CITY OF ALBUQUERQUE

August 1, 2007

Re: Randolph Building, 1711 Randolph St. SE
Approval of 90-Day Temporary Certificate of Occupancy (C.O.)
Engineer's Stamp dated 02/15/07 (M-15/D042)
Certification dated 07/31/07

**Re: Randolph Building, 1711 Randolph Road SE, Grading and Drainage Plan
Engineer's Stamp undated (M15-D42)**

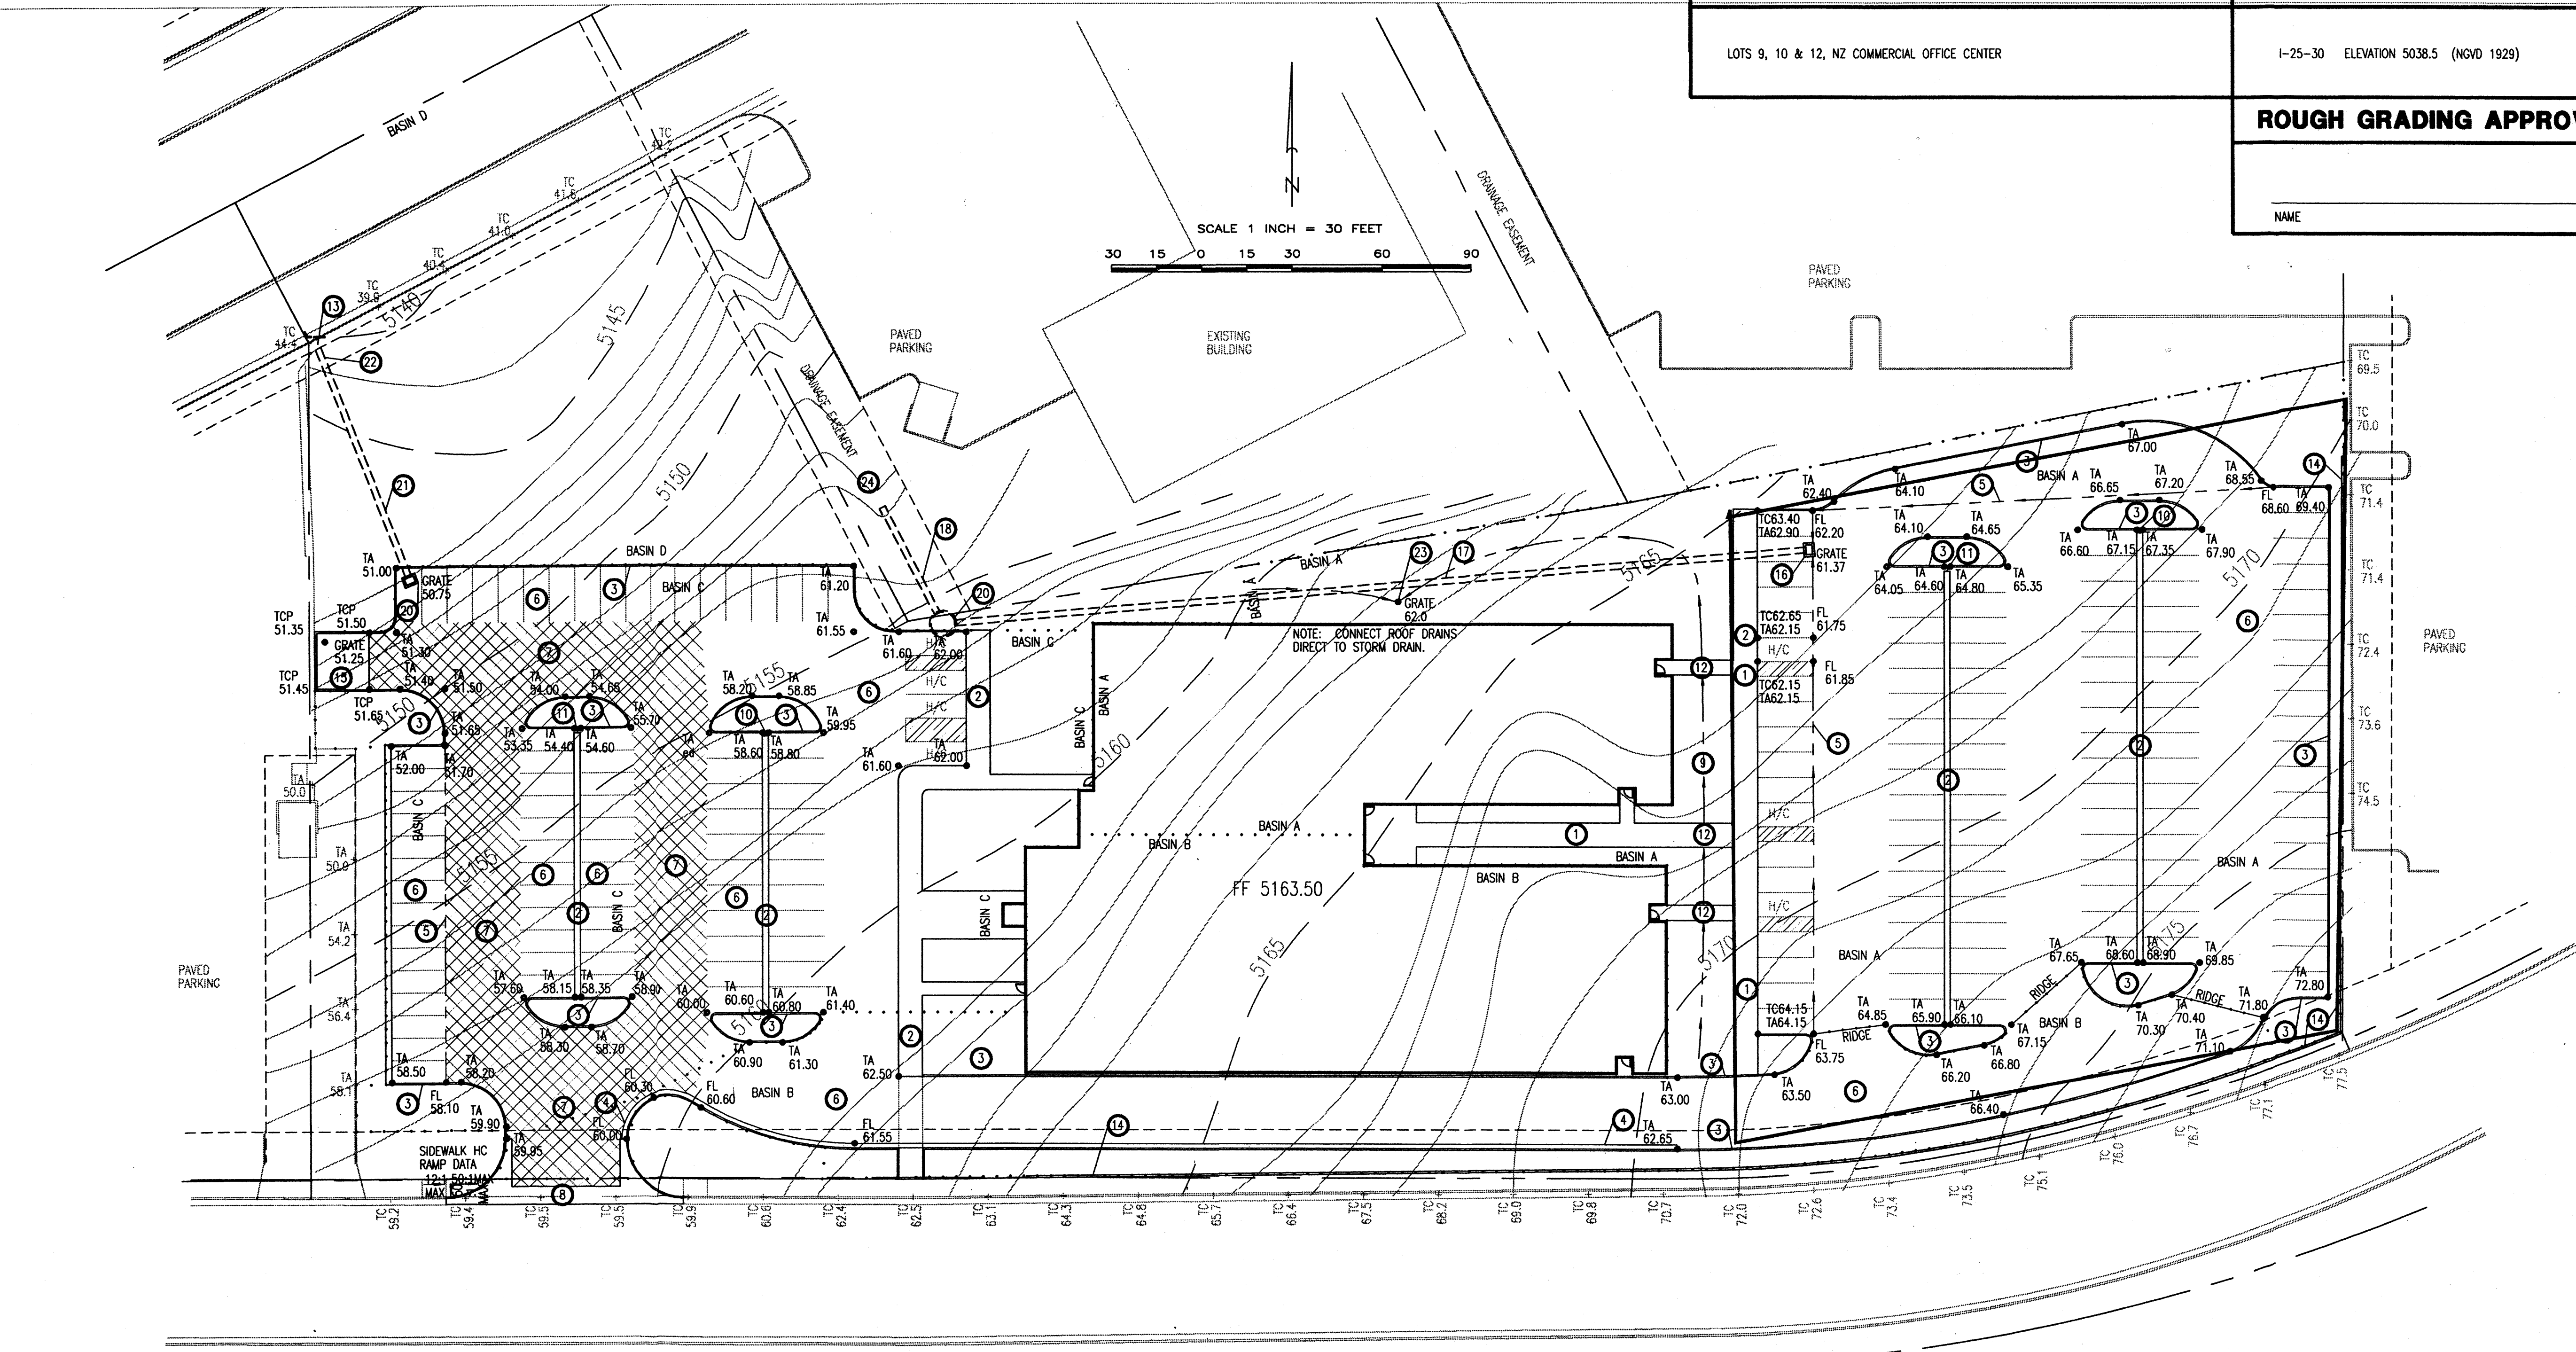
1. The plan must be signed, stamped, and dated by an engineer licensed within the state of New Mexico.
2. Complete the elevation and slope data within keyed notes 17, 18, 19, and 21.

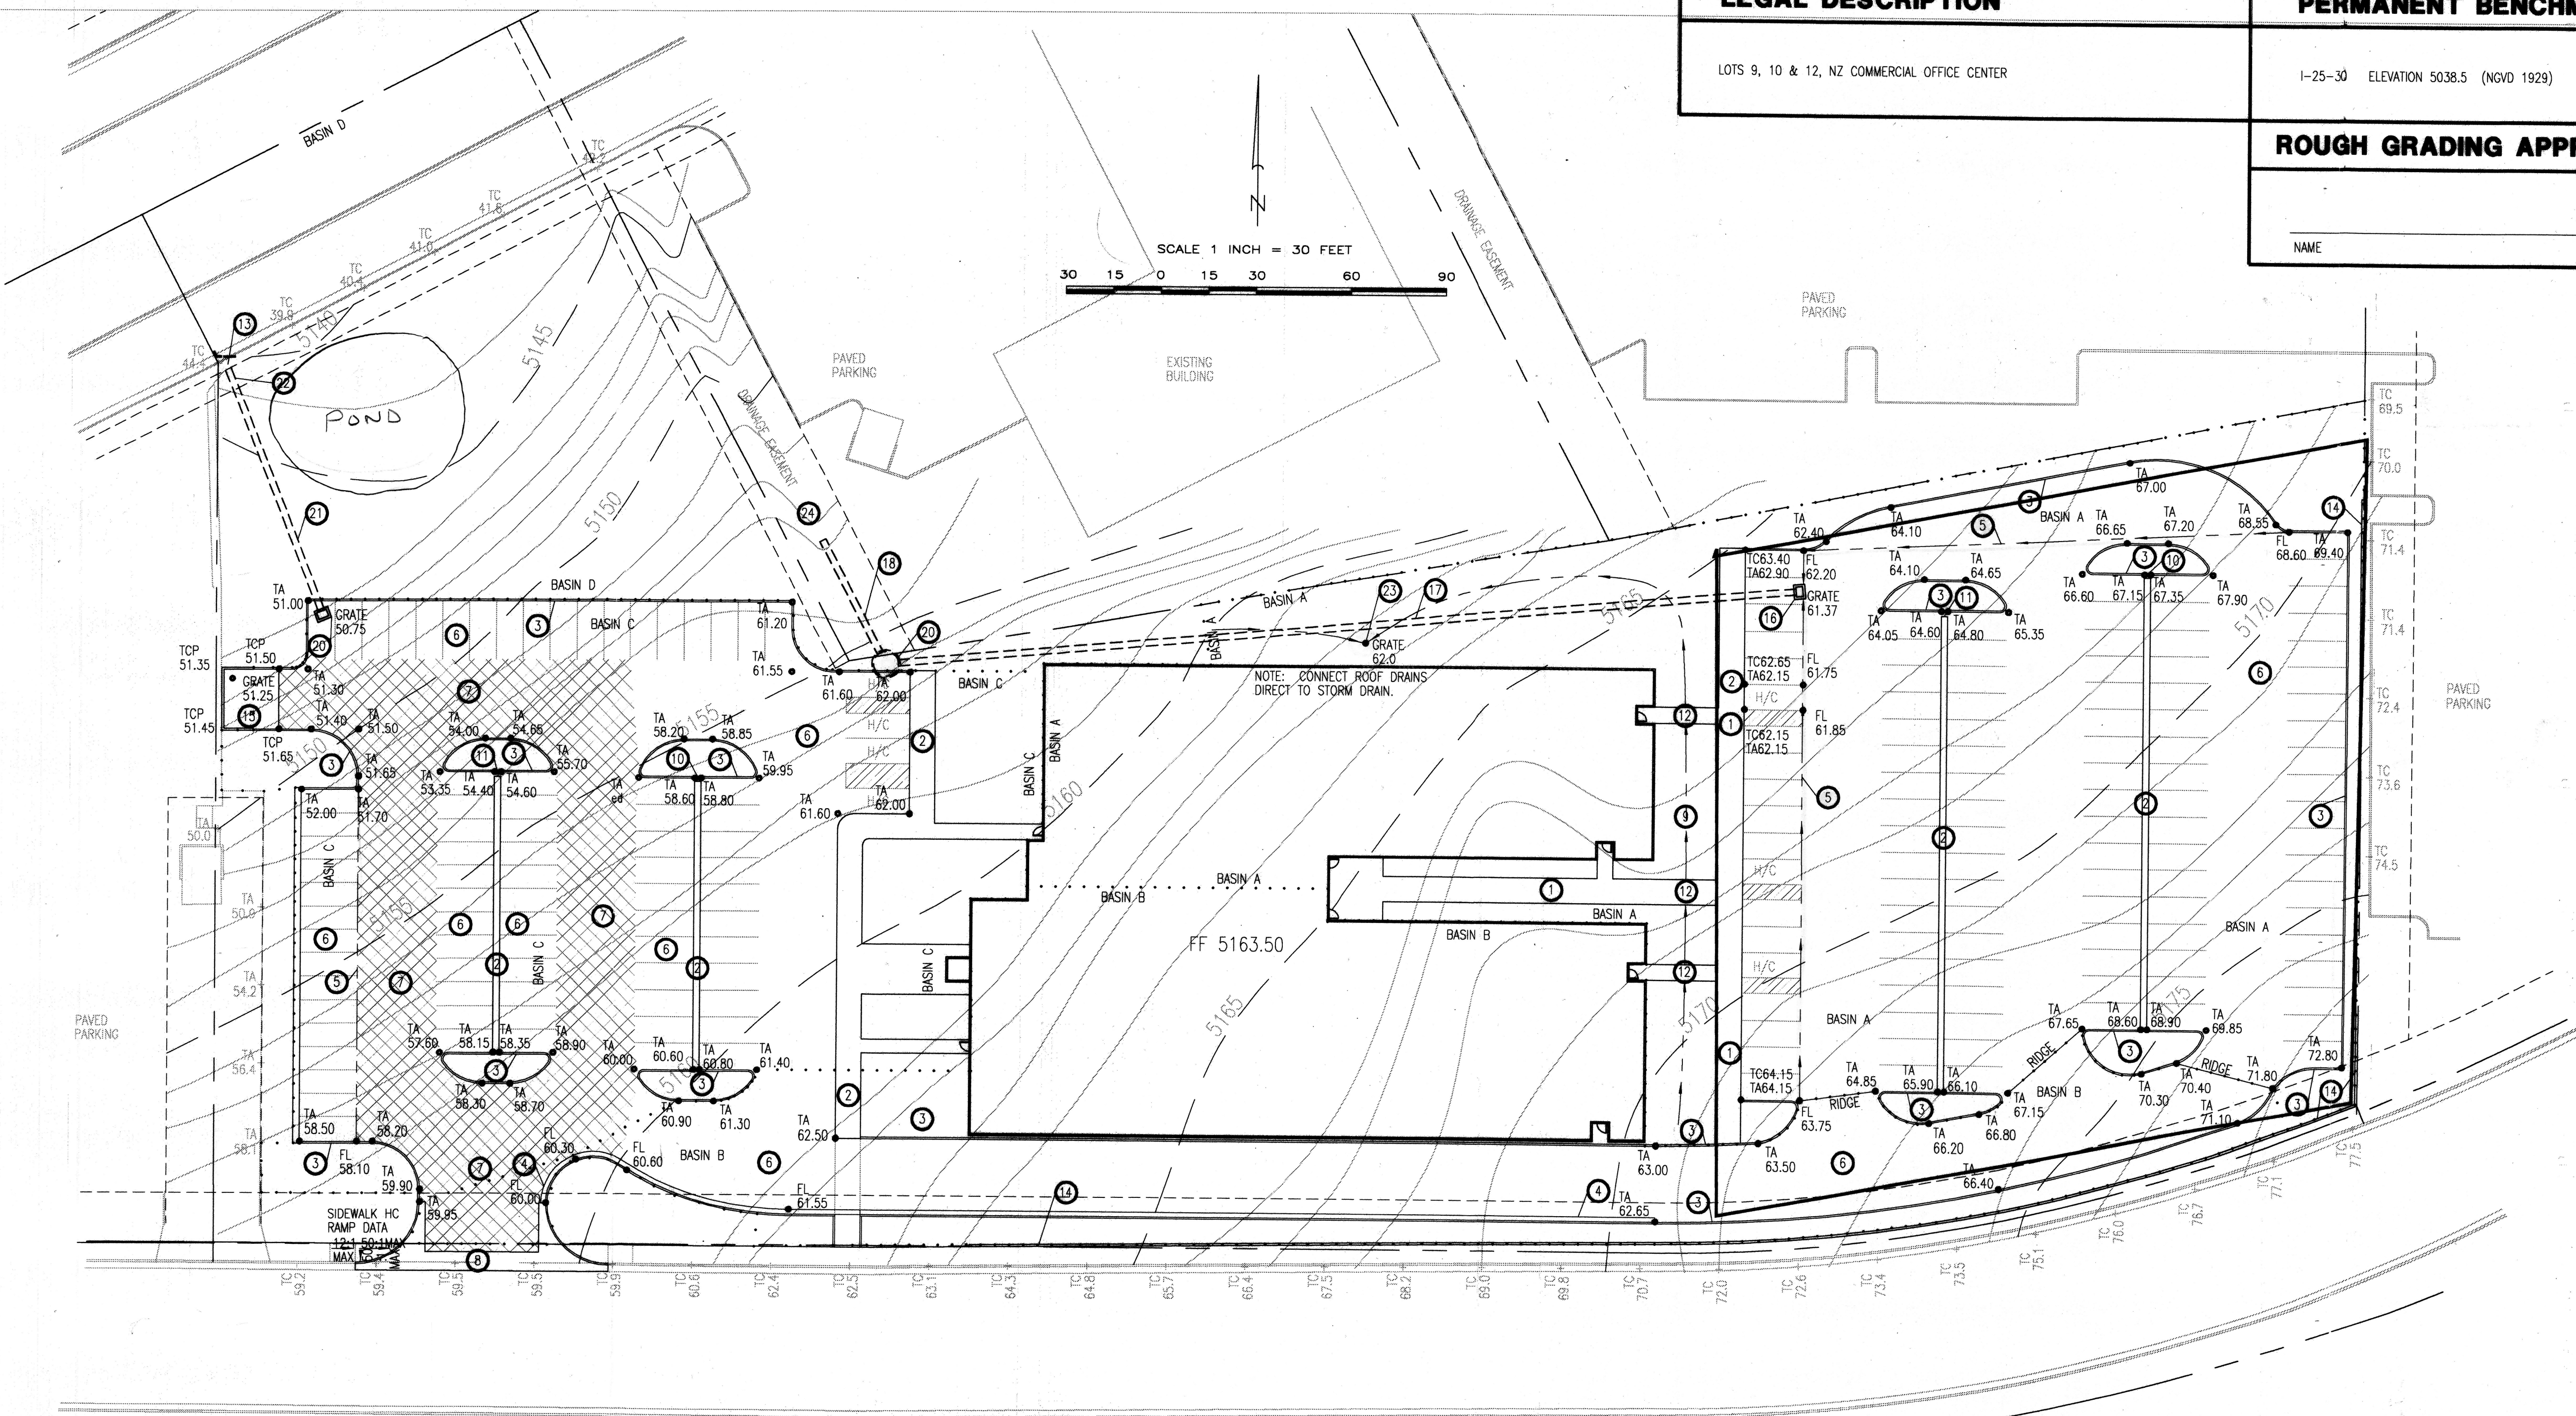
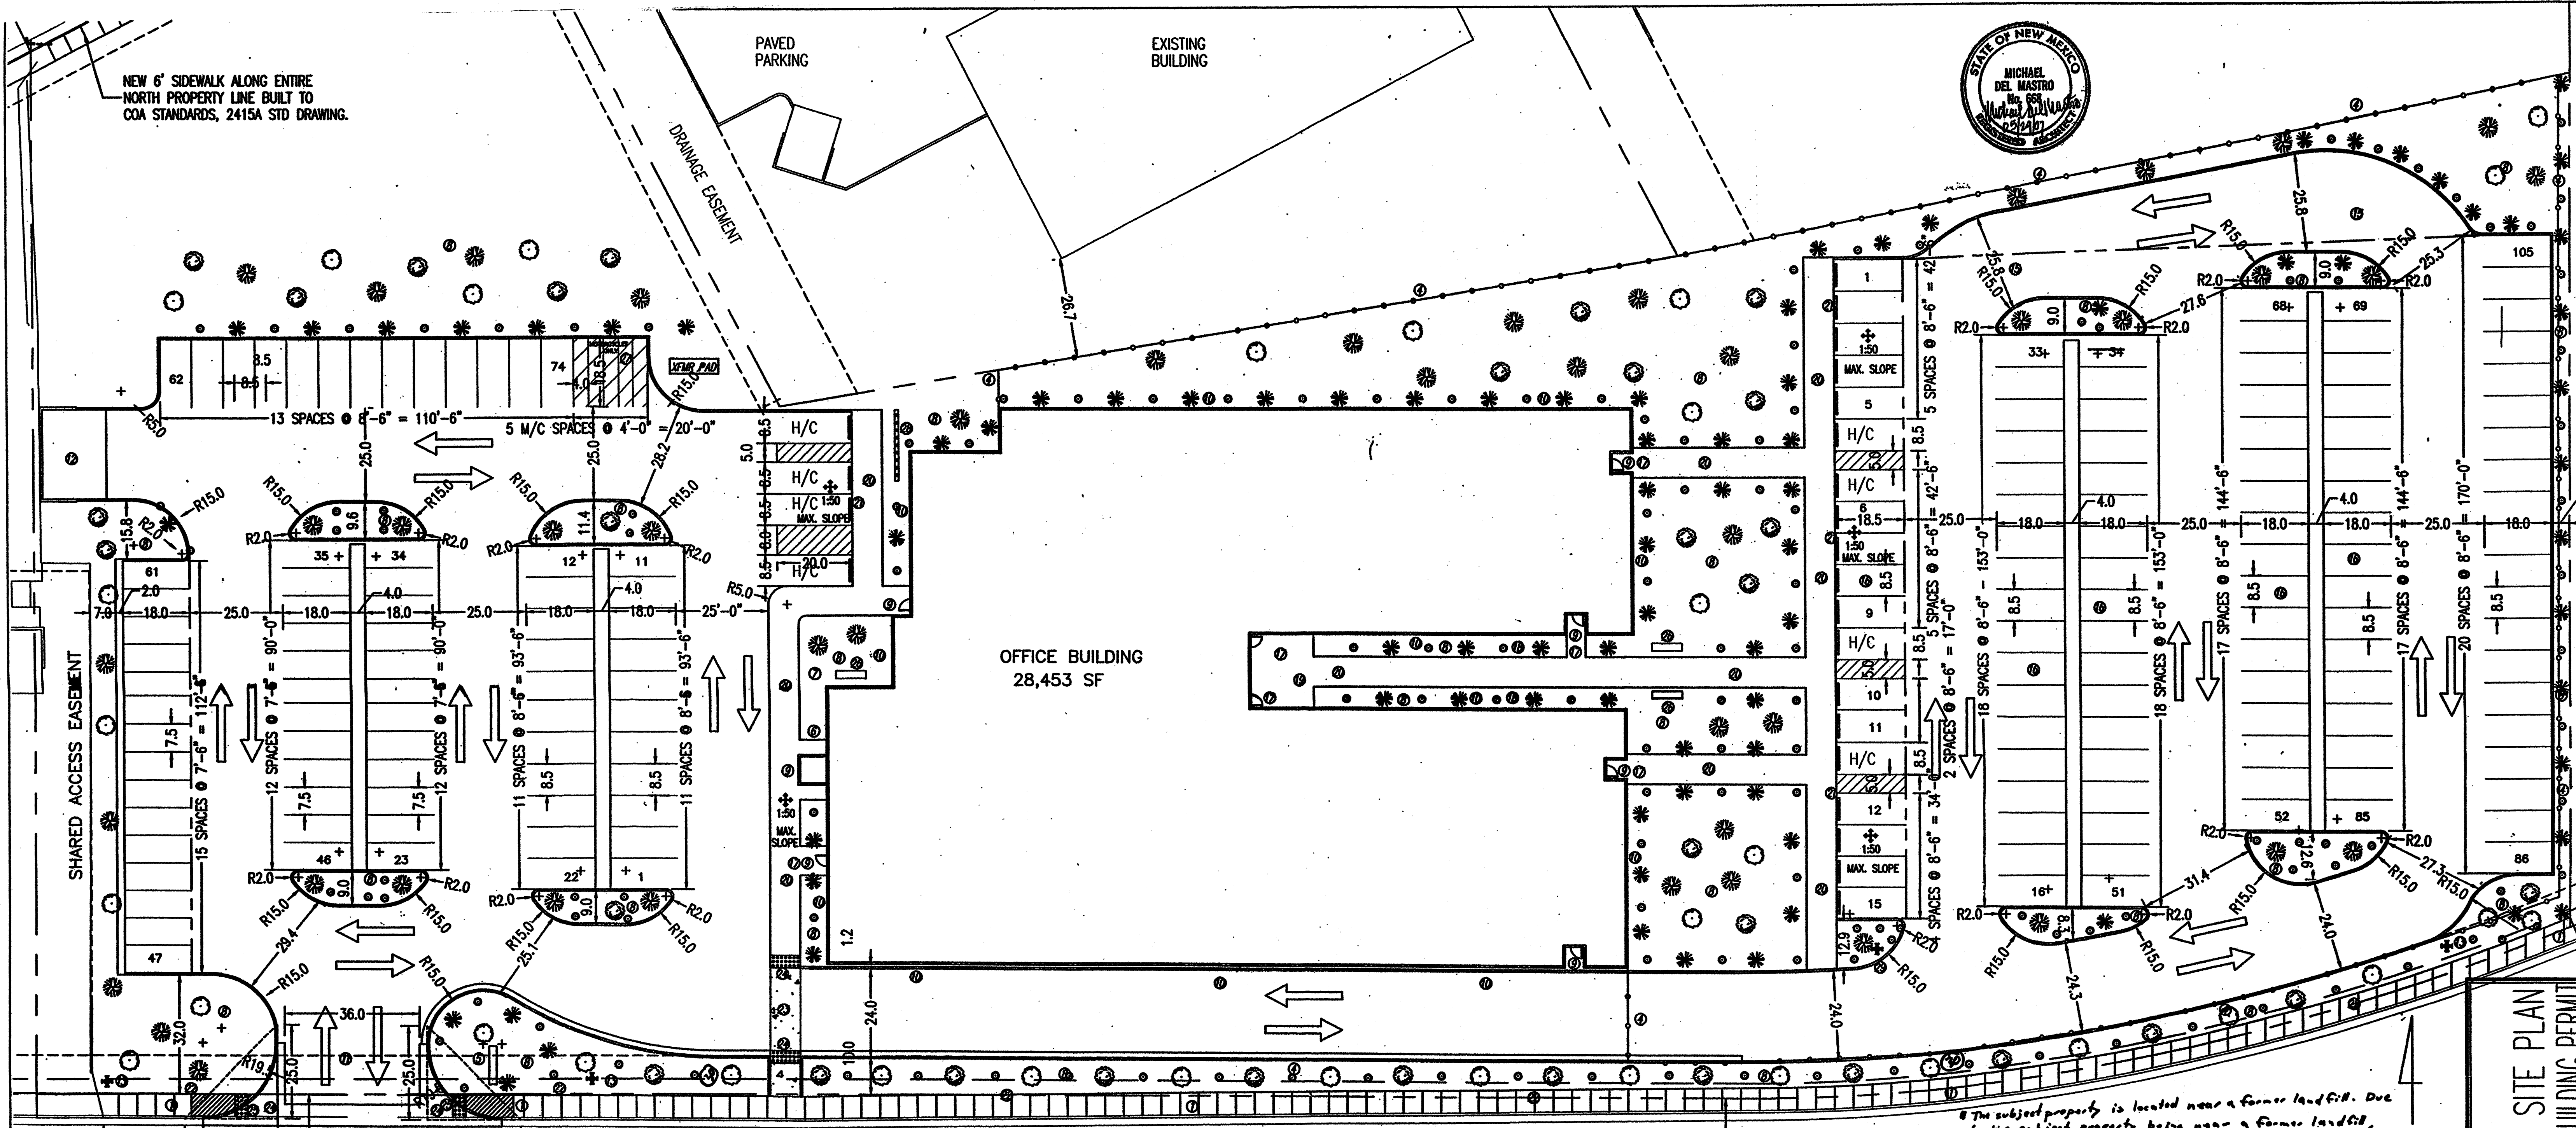
1. Please show the location of the nearest driveway on the adjacent lot.
- ✓2. List the width of all parking islands.
- ✓3. Please show a vicinity map and a north arrow on the traffic circulation layout.

4. Show the location of all items that may impede the ADA pathway (fire hydrants, poles, etc.). *Move note 13*
5. Define all linetypes and provide a legend.

- ✓6. Provide a copy of solid waste approval.
- ✓7. Specify what is meant by the information in keyed note 5.
- ✓8. Please refer to all applicable City Specifications by standard number.

- ✓9. Provide a copy of the sidewalk easement for the sidewalk along Randolph that is located outside of the public right of way. *- put on plat*
10. Show the location of all wheelchair ramps and provide details. *- need truncated domes*

- ✓11. Provide geometric information for the handicapped spaces. Note that the handicapped spaces must be a minimum of 8.5 feet in width. In addition, the handicapped spaces must include an 8-foot wide van access aisle (located to the right of the handicapped space); all other aisles should be 5 feet in width.

- ✓12. A 2-foot overhang is allowed for standard parking spaces. However, two standard spots cannot share the overhang. Therefore, a 4-foot overhang area should be provided for spaces that abut each other. In addition to this, please note that each standard space can be 18 feet in length if an overhang is provided.

14. Are you replatting this site? *Yes*
- ✓15. What is the radius at the proposed entrance?
- ✓16. Call out the width of all drive aisles.
- ✓17. A scale must be shown on the plan. Per the Development Process Manual, Chapter 27, Section 2, Part B.1, only the following scales may be used:
- 1" = 50'
 - 1" = 40'
 - 1" = 20'
 - 1" = 10'
 - 1" = 100' (for overall layouts only)
